From: Martyn White <Martyn.White@arun.gov.uk>
Sent: 11 June 2021 16:51
To: Planning.Responses <Planning.Responses@arun.gov.uk>
Cc: Simon Davis <Simon.Davis@arun.gov.uk>
Subject: Y/49/21/RES

Y/49/21/RES

Land East of Drove Lane Yapton BN18 0EB

Approval of reserved matters following Y/92/17/OUT for 300 No. dwellings covering landscape, layout, scale & external appearance (resubmission following Y/78/20/RES).

Drawing Title:
HOUSE TYPES
BEW
ELEVATIONS & FLOOR PLANS

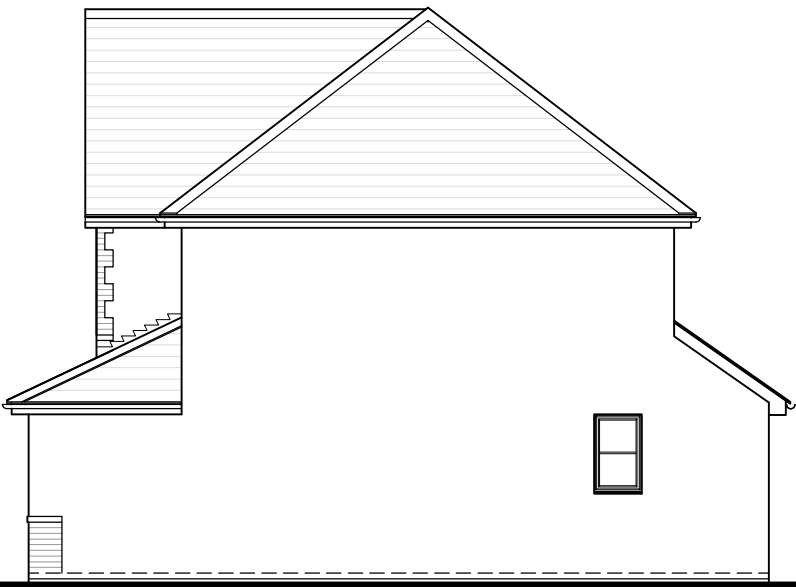
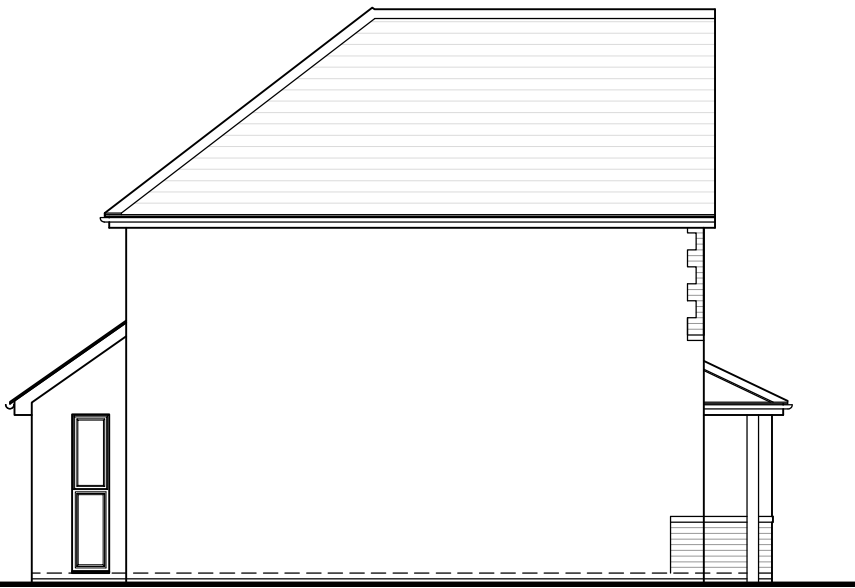
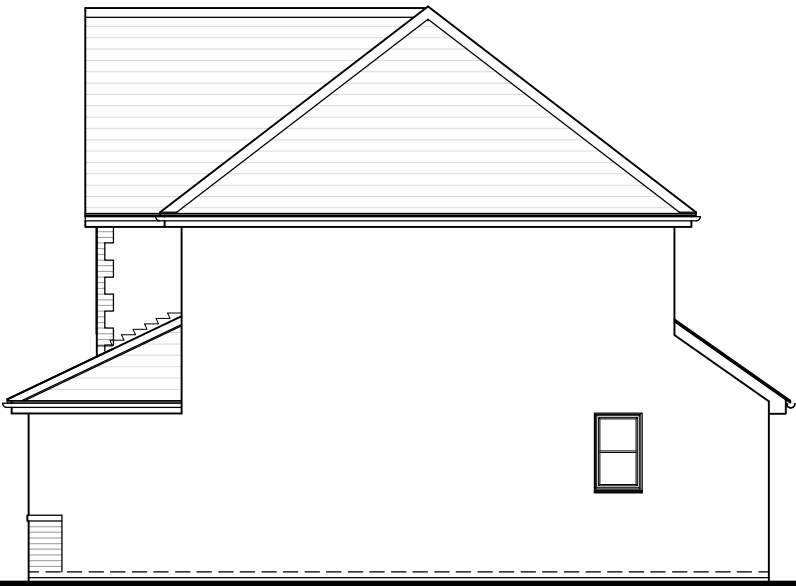
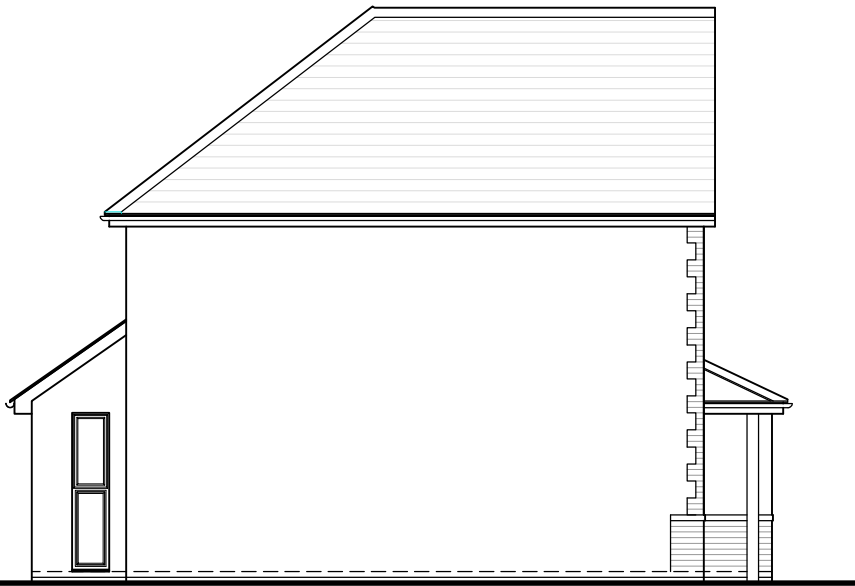
Whilst it is positive to understand that some thought has been given to the design of properties in that they would be specific to this character area, it is important to stress that they should be high quality purpose made designs which should be sensitive to their specific location, as opposed to the more standard 'anywhere', housing designs. Whilst some attempt has been made to vary the designs, it is clear that they are closely related to others found in the proposed development.

The success of such designs will be dependent upon the materials used, and detailed design considerations. This includes boundary treatments where I note that a variety of materials are proposed, including flint. The use of modern materials such as concrete tiles as indicated on the materials plan is not appropriate and it is recommended that more appropriate, traditional materials such as natural slate, plain clay tiles and good quality bricks are used. Good quality joinery, finishes, and detailing also need to be included in the scheme. The result will be an enhanced entrance to both the development and the conservation area. Consequently, such designs are not appropriate for their sensitive location.
